Appeal Decision

Appeal Ref: APP/R4408/D/21/3266868

1 Hunters Cottage, Pogmoor Lane, Barnsley S75 2JS

- The appeal is made under section 78 of the Town and Country Planning Act 1990 against a refusal to grant planning permission.
 - The appeal is made by Mr D Sykes against the decision of Barnsley Metropolitan Borough Council.
 - The application Ref 2020/0697, dated 1 July 2020, was refused by notice dated 23 October 2020.
 - The development proposed is described as a garage outbuilding to side garden.
-

Drawing Number  
ABAPA2020DSykes/ 02

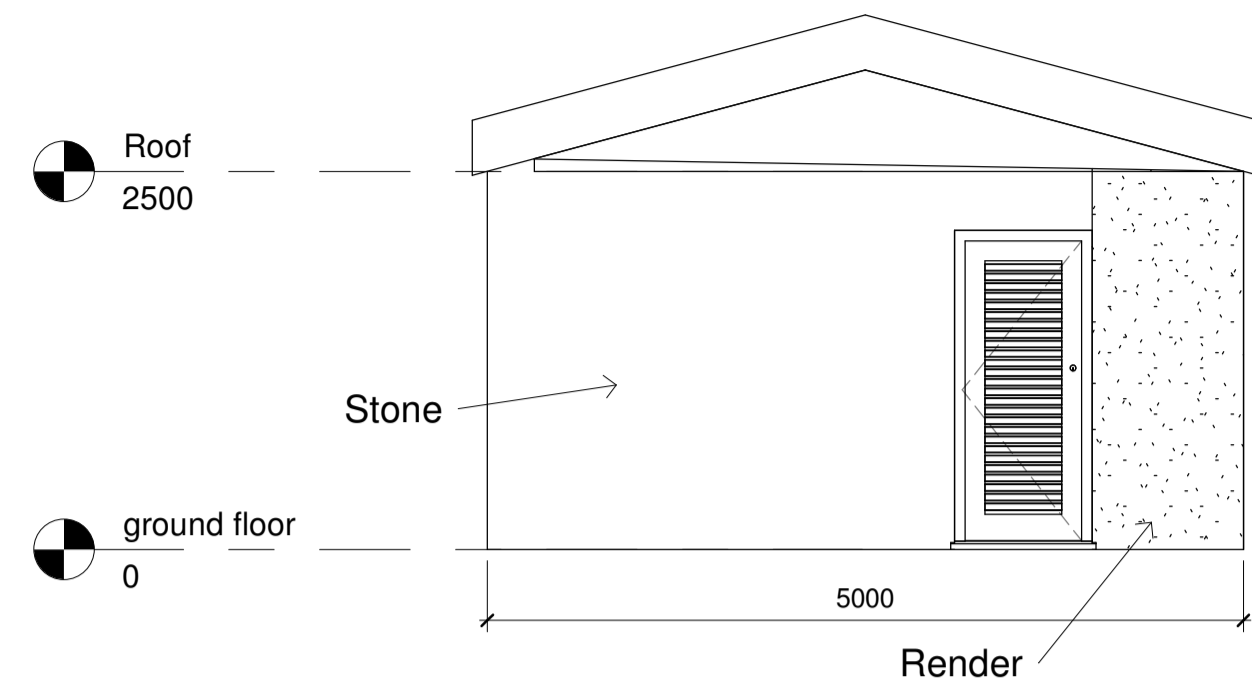
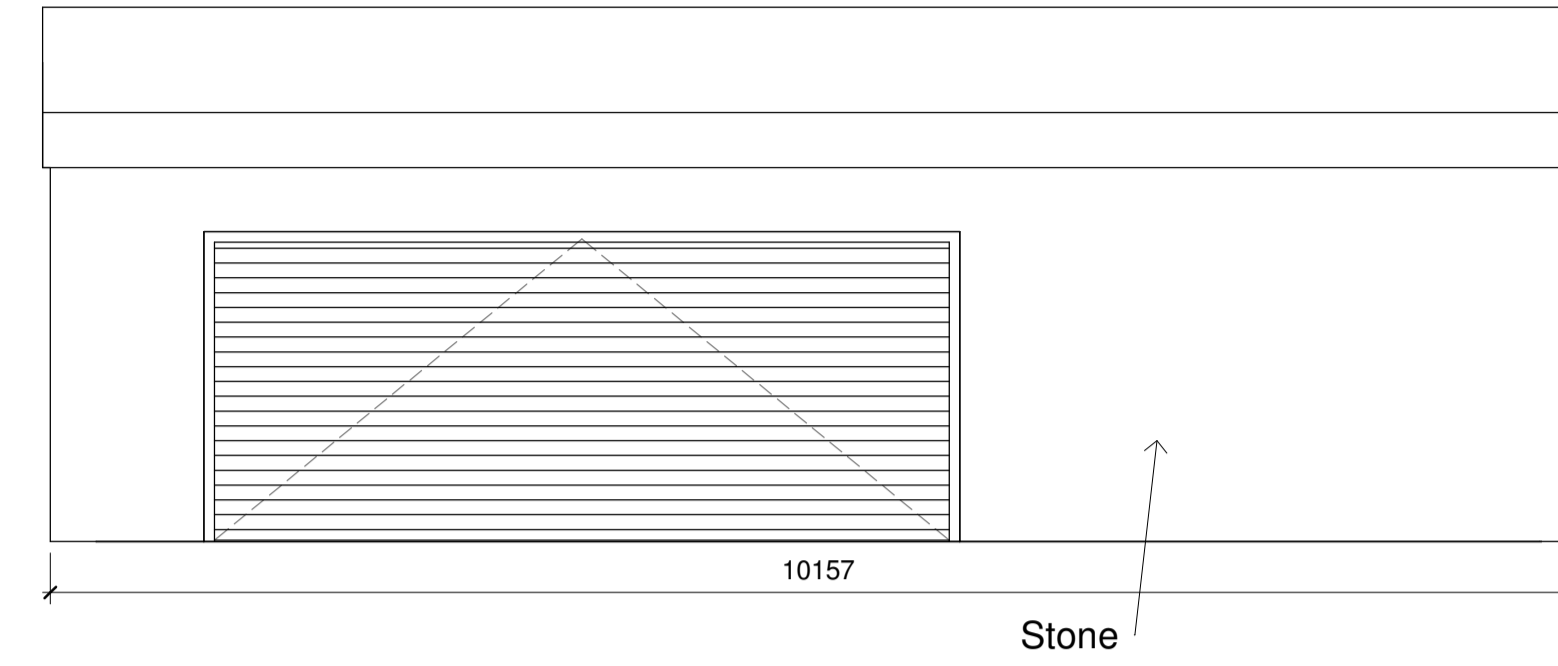
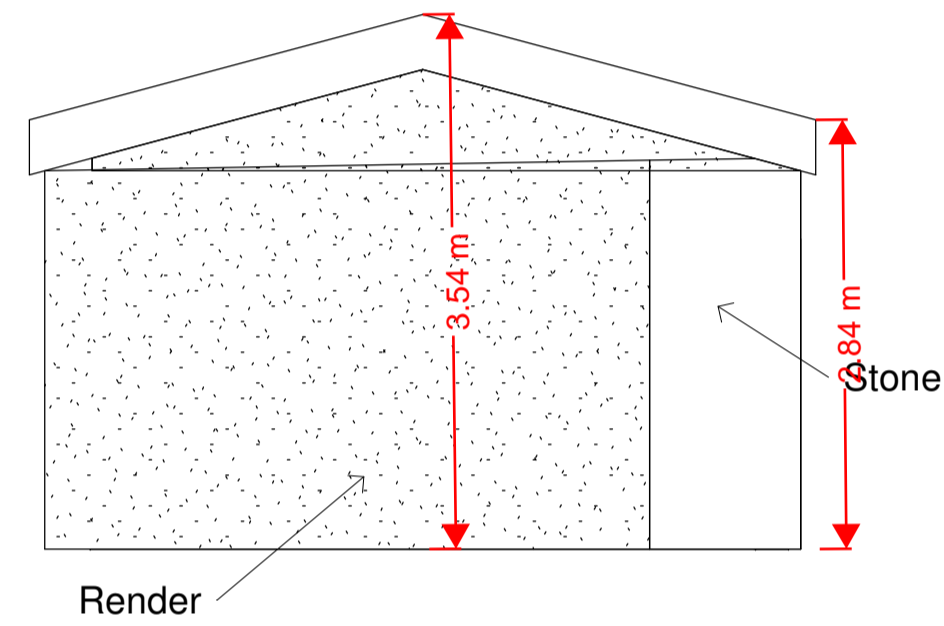
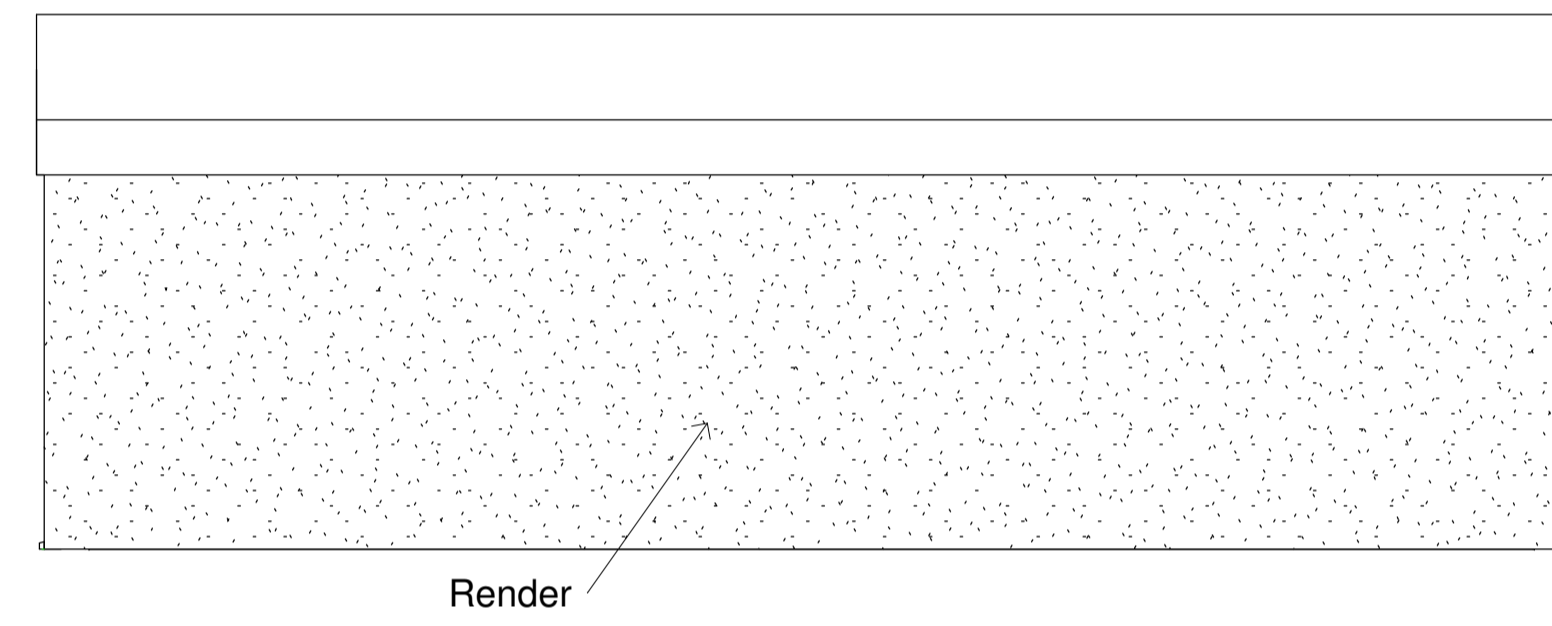
4. The submitted plans show that the proposed outbuilding would be some 5 meters deep and over 10 meters wide, incorporating a large garage door and separate room.

5. I note that in the course of the determination of the application as a result of discussions between the appellant and the Council, the submitted plans have been amended to incorporate a pitched roof matching the existing dwelling and the other outbuilding on the appeal site. The Officer's report details that the "eaves and ridge height of 2.85m and 3.54m respectively".

6. The Council details that the proposed building is not deep enough to function as a garage. I have not been provided with a copy of the South Yorkshire Residential Design Guide (SYRDG) I understand that this document details a recommended depth for garages, being 6m or 5.5m where a roller shutter door is utilised. Other than querying how the building can be argued, by the Council,
